**From:** Nolan, Chris <Chris.Nolan@lancashire.gov.uk>  
**Sent:** 22 November 2017 13:37  
**To:** Harriet McCartney; planning  
**Cc:** LHS Customer Service  
**Subject:** D3.2017.0993 - 22 Shireburn Avenue Clitheroe RD  
**Attachments:** 17 0993 Amendment 22Nov17.pdf

Planning Application No: 3/2017/0993

Proposal: Removal of garage and erection of new integral garage with single storey rear and loft extension.

Location: 22 Shireburn Avenue Clitheroe BB7 2PN

Rev.	Description	By	Date
	Project Daniel Bone 22 Shireborn Avenue, Clitheroe, BB7 2PN	Drawing Title Proposed Layouts	
		Drawing No. BONE/02	Rev. A
		Drawn by J.L.	Scale 1:50
			Date Nov '17

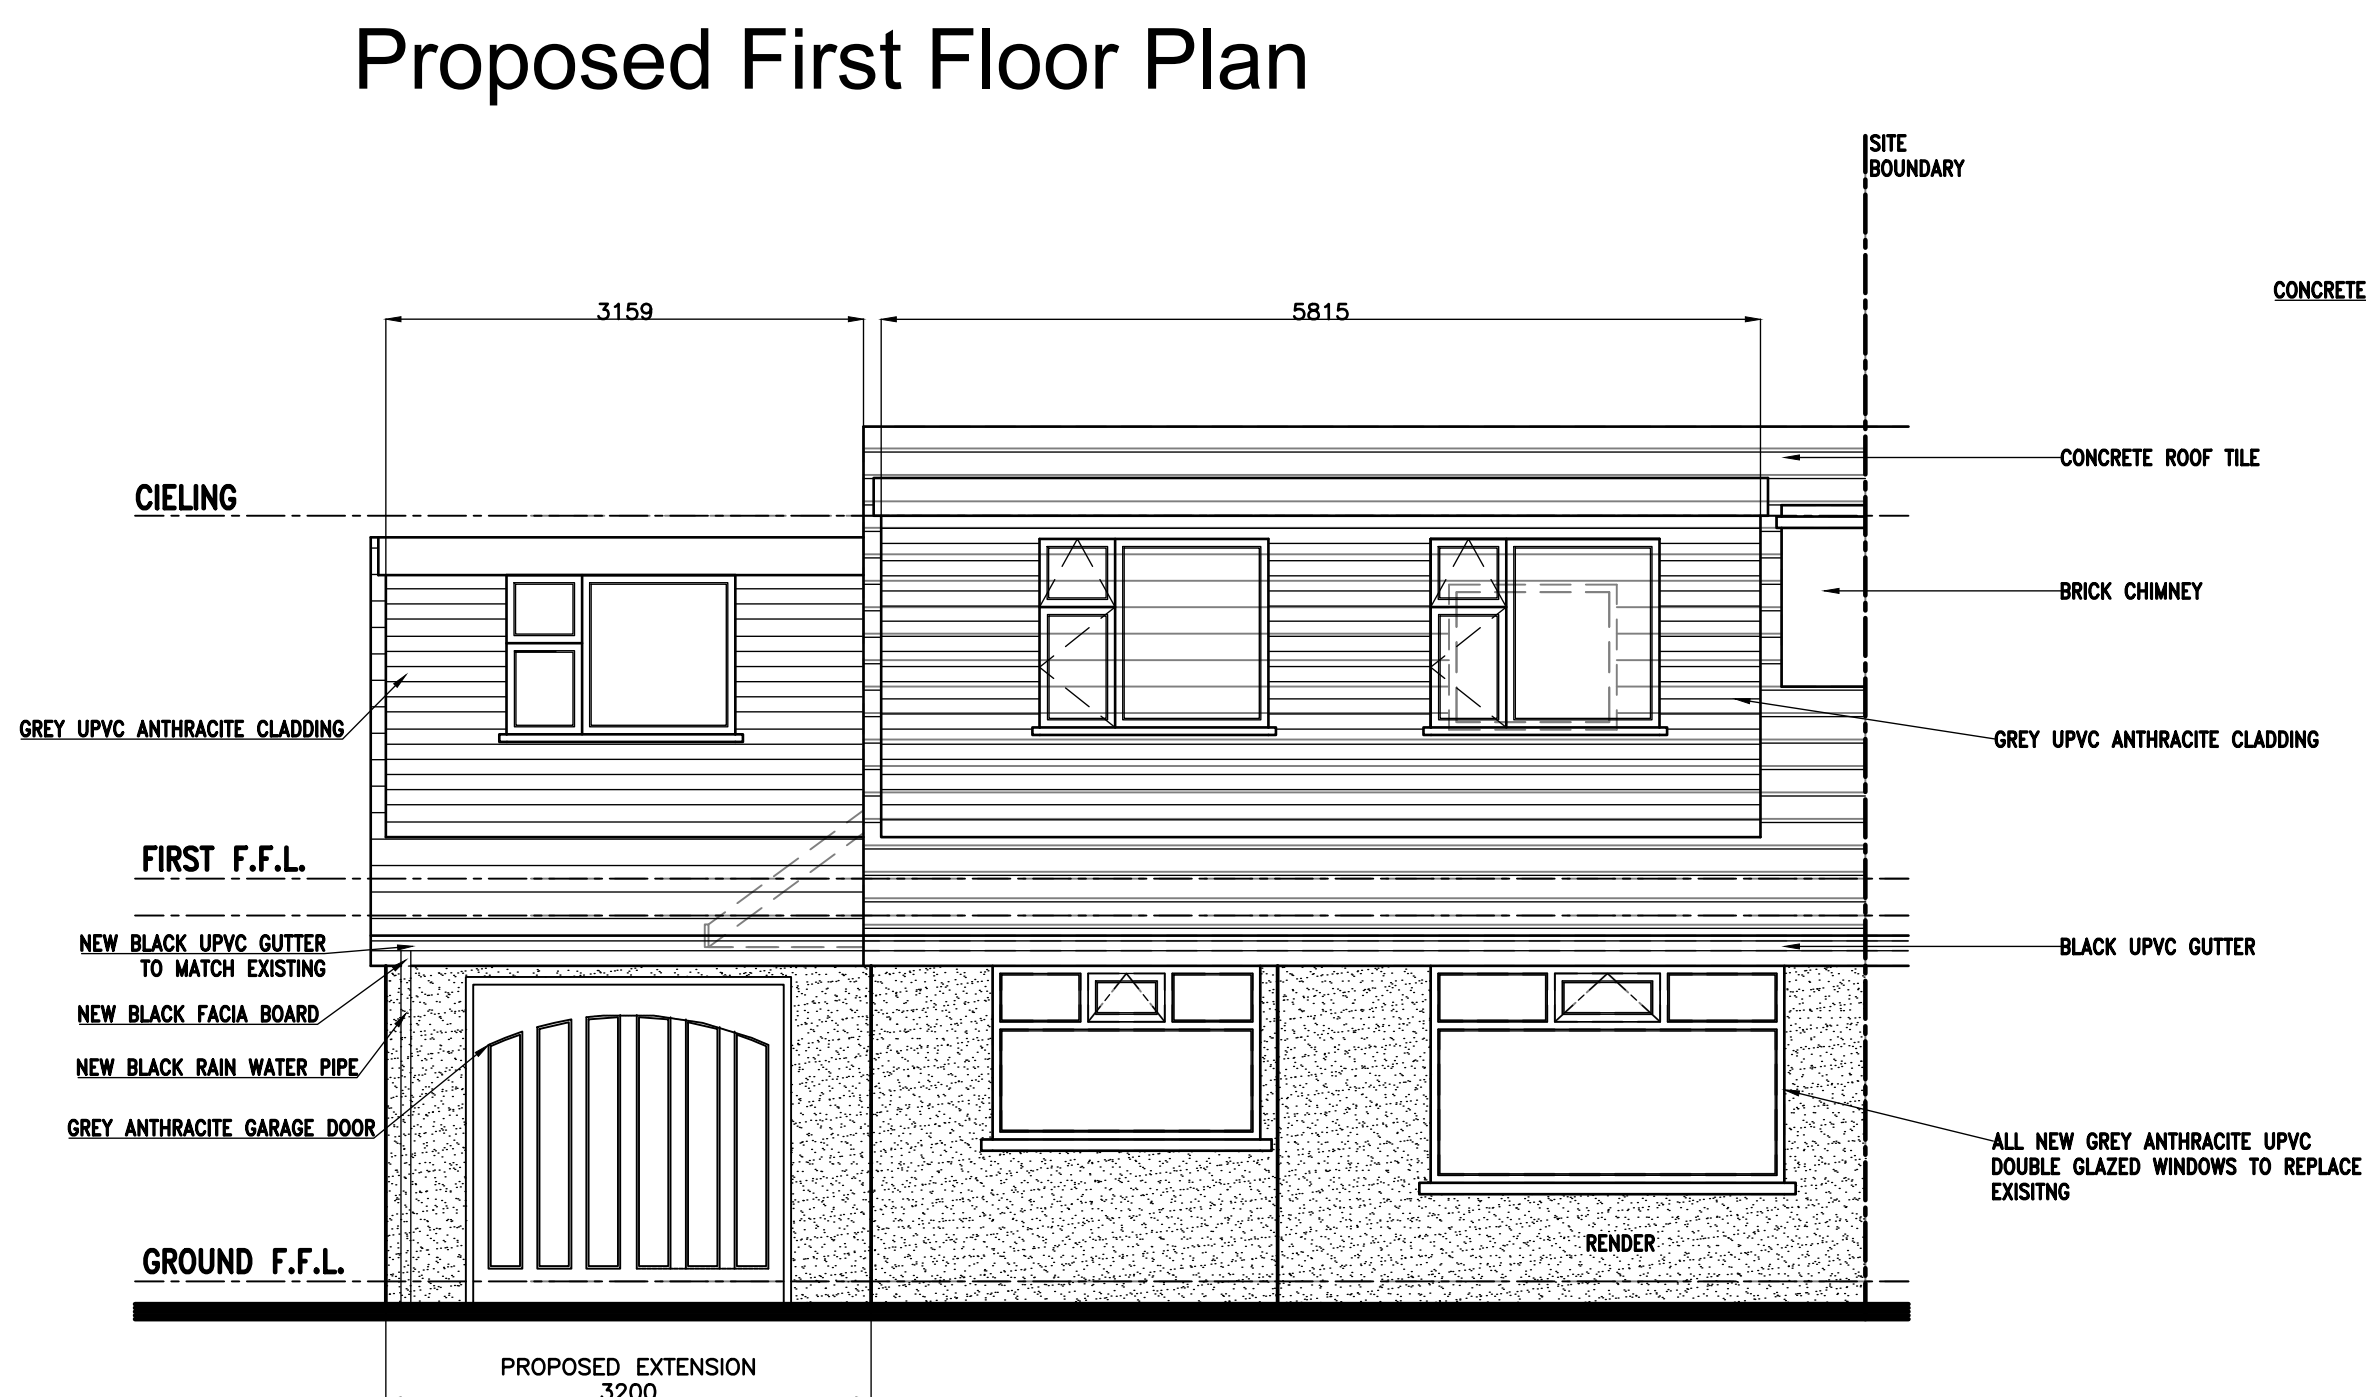
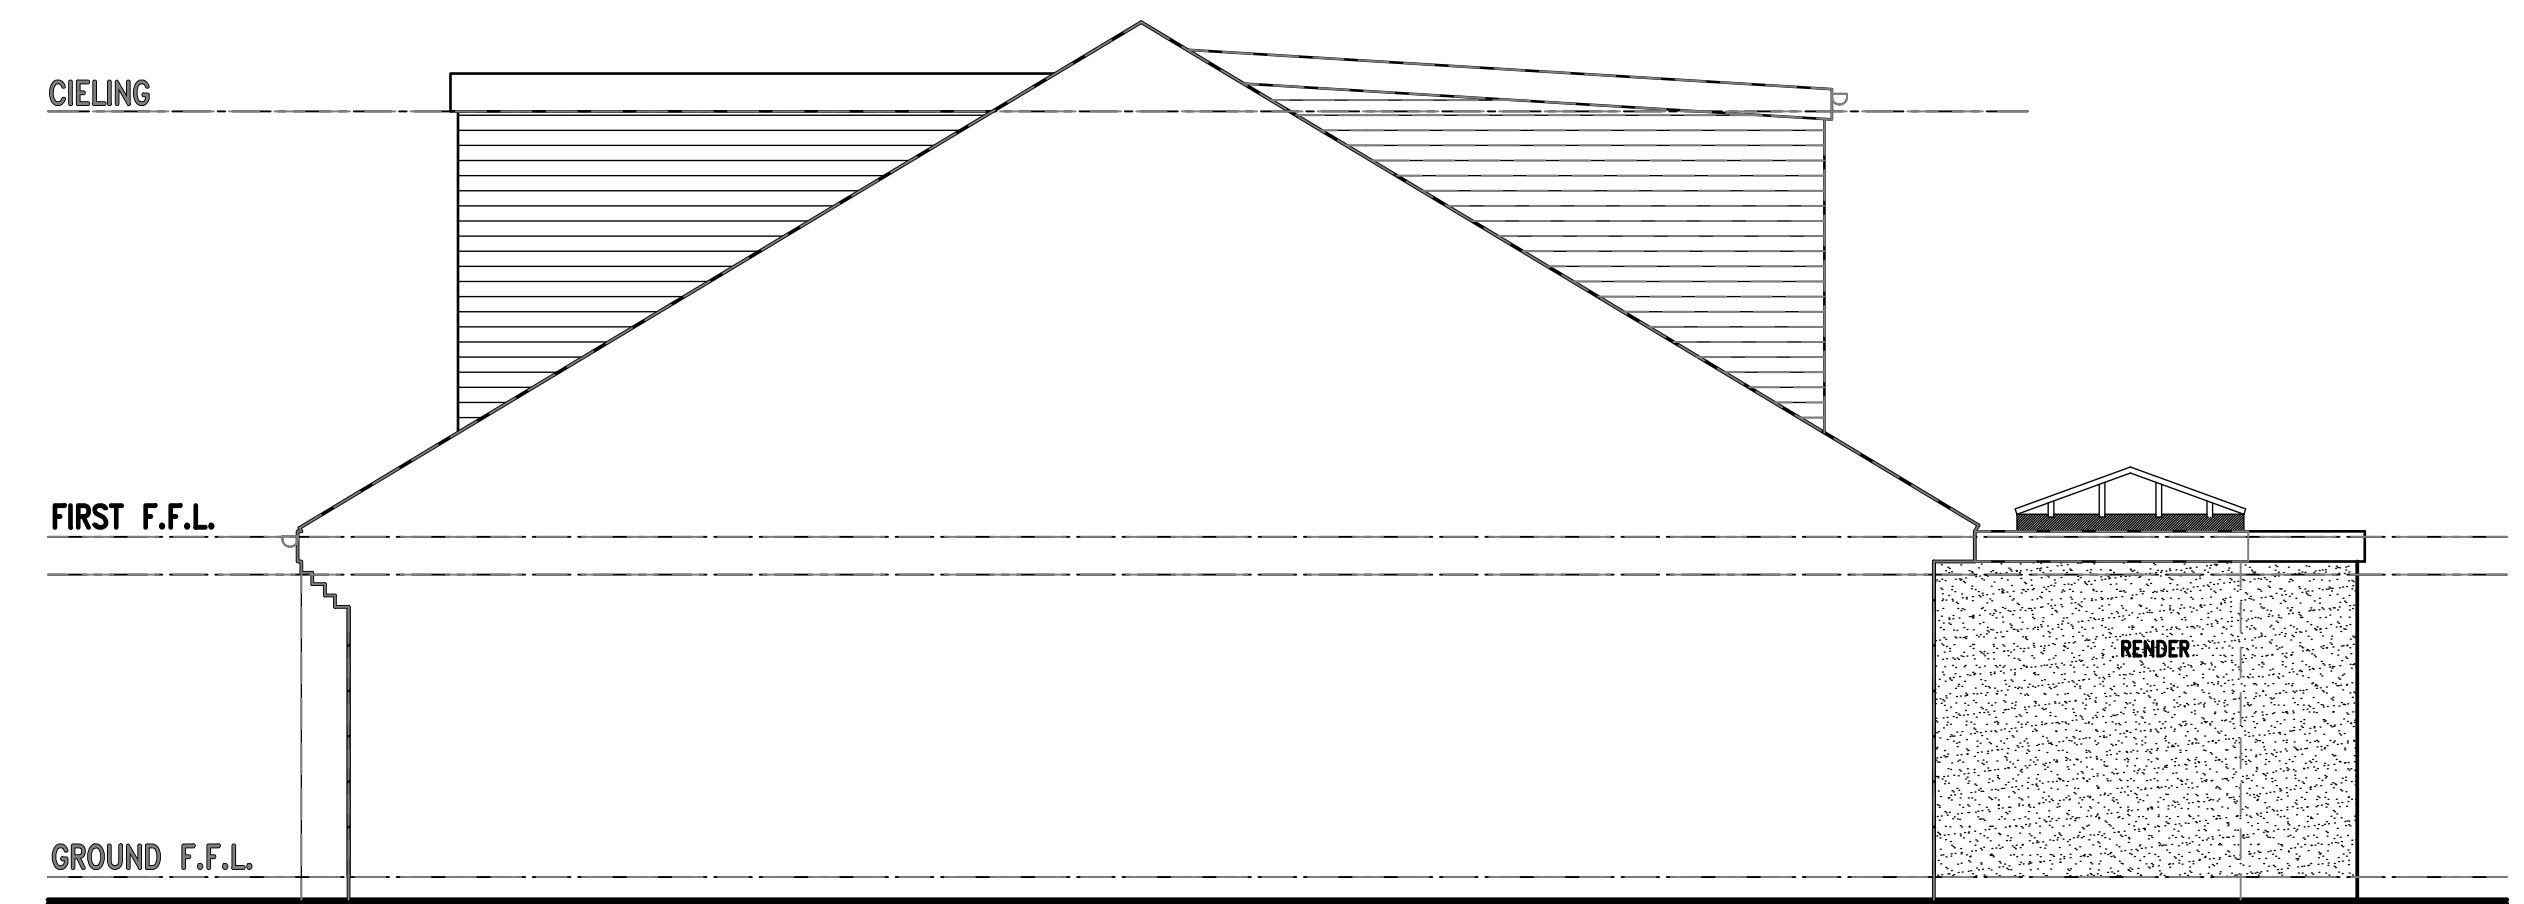
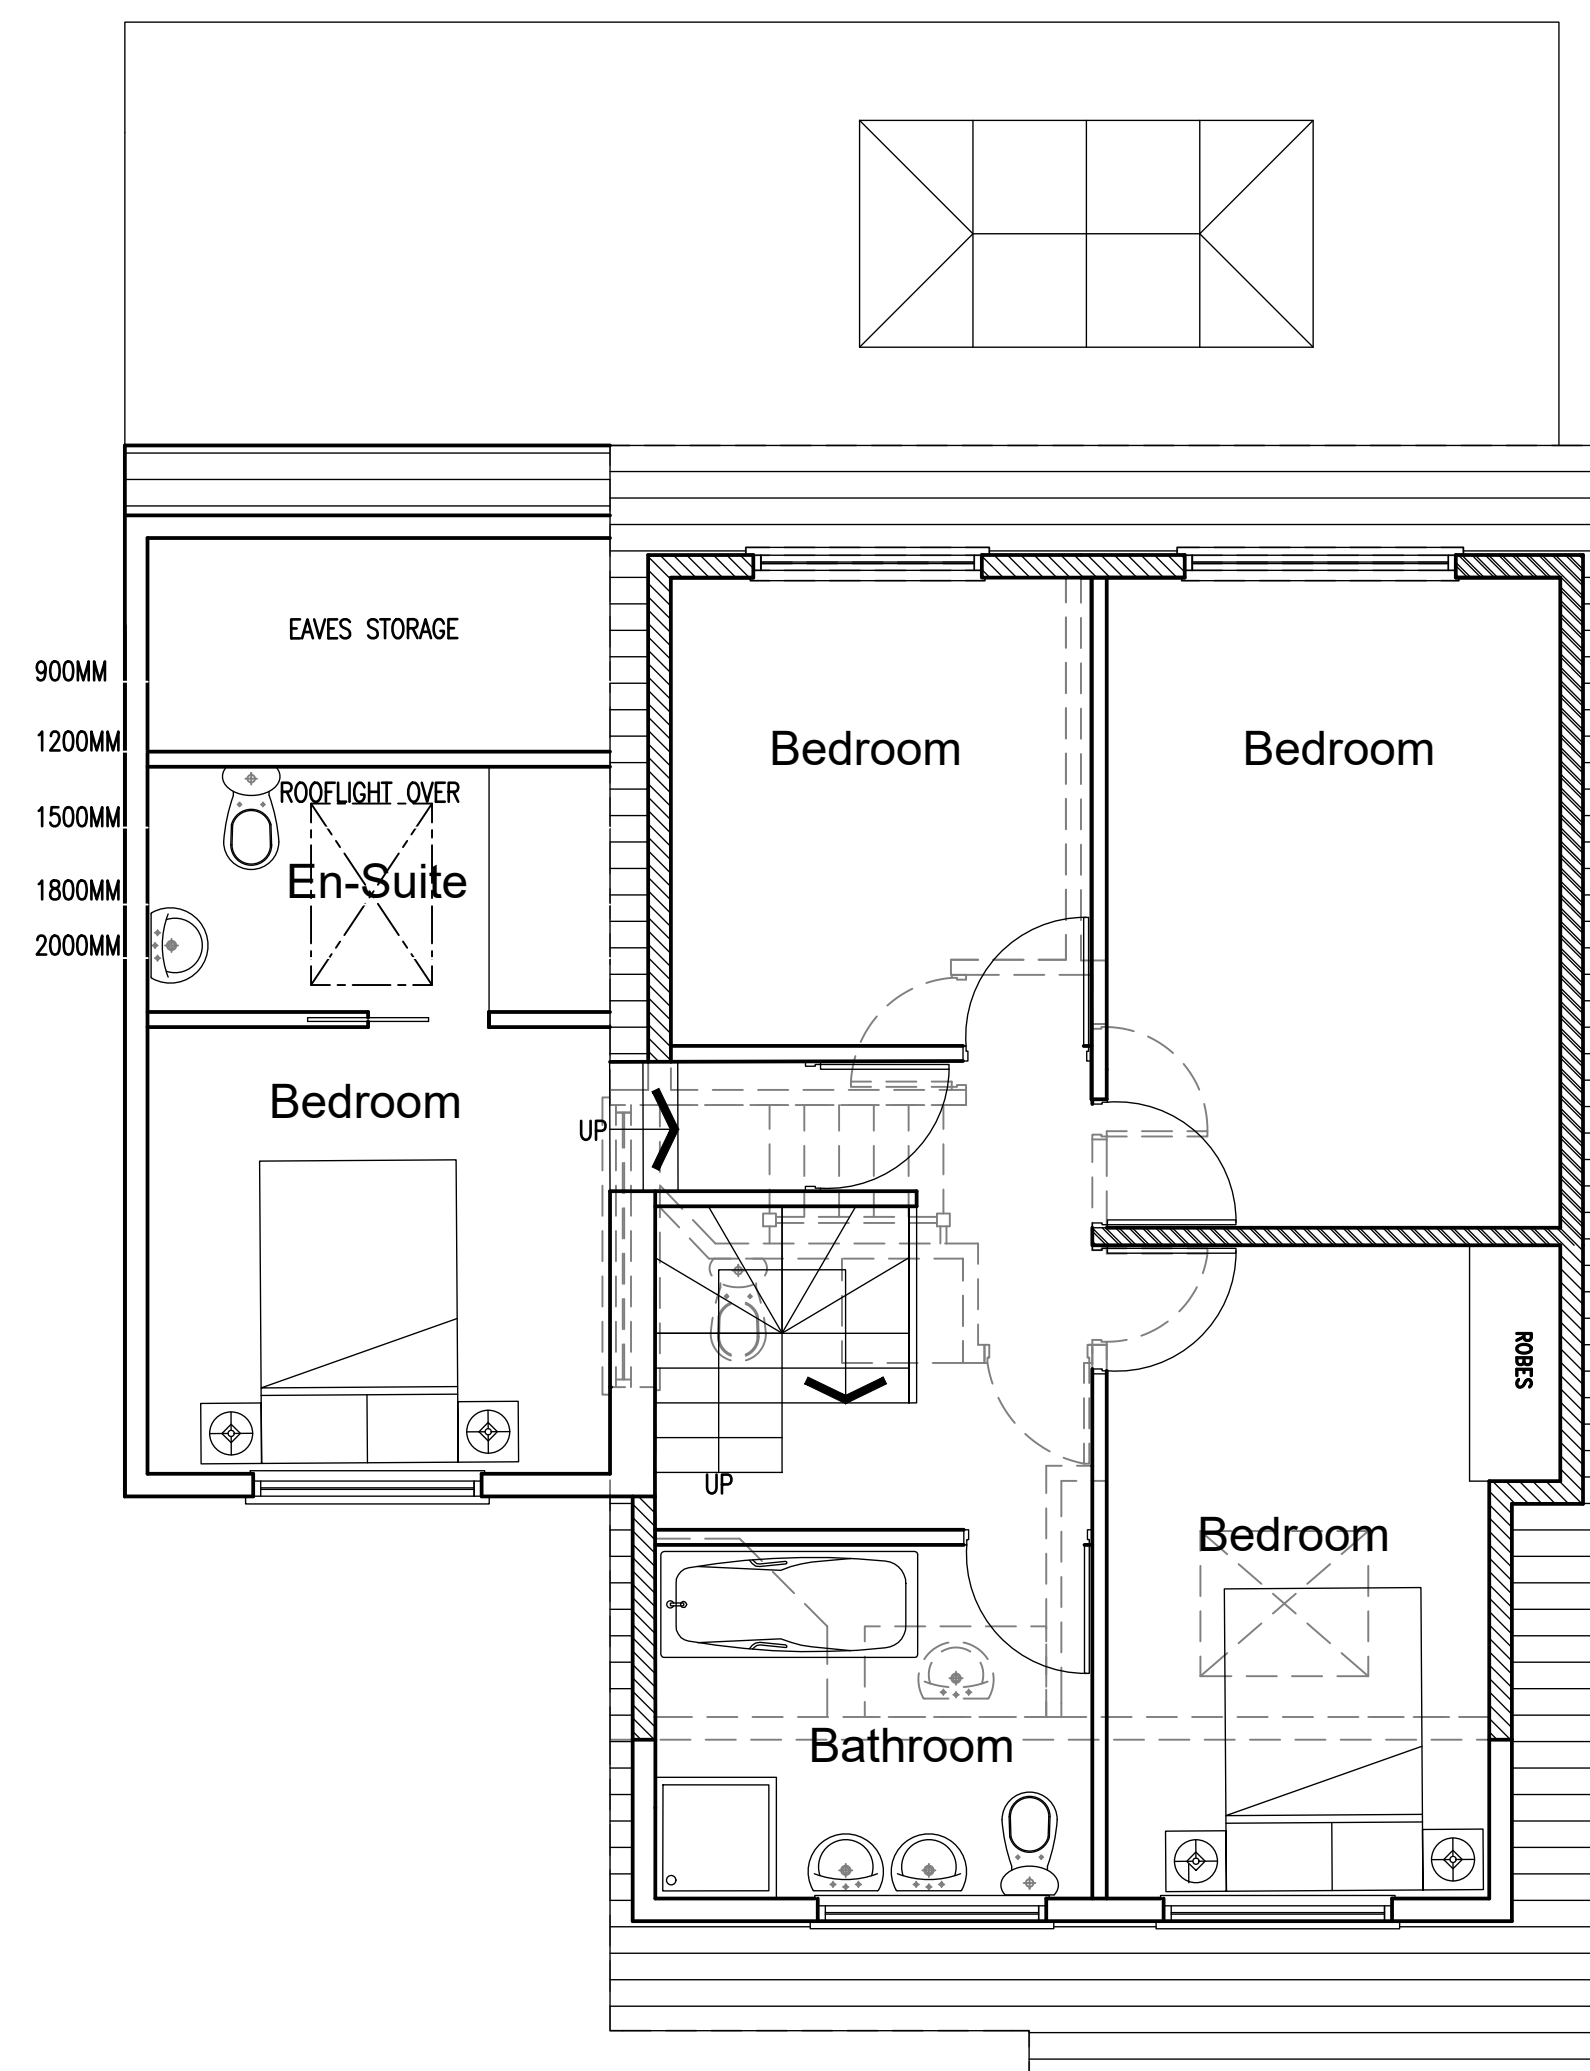
With regard to the above planning application. The attached plan and the amended site plan, as view on the website, would indicate that the site will provide the required parking for a four bedroom dwelling. The application will use an existing vehicle crossing and therefore there will be no need for alterations to the highway. The amended site plan also indicates that there will be space to store the household refuse at the rear of the building with a walkway to allow the bins to be placed at the front of the property for collection. In light of the new information, I would remove my objections to the application.
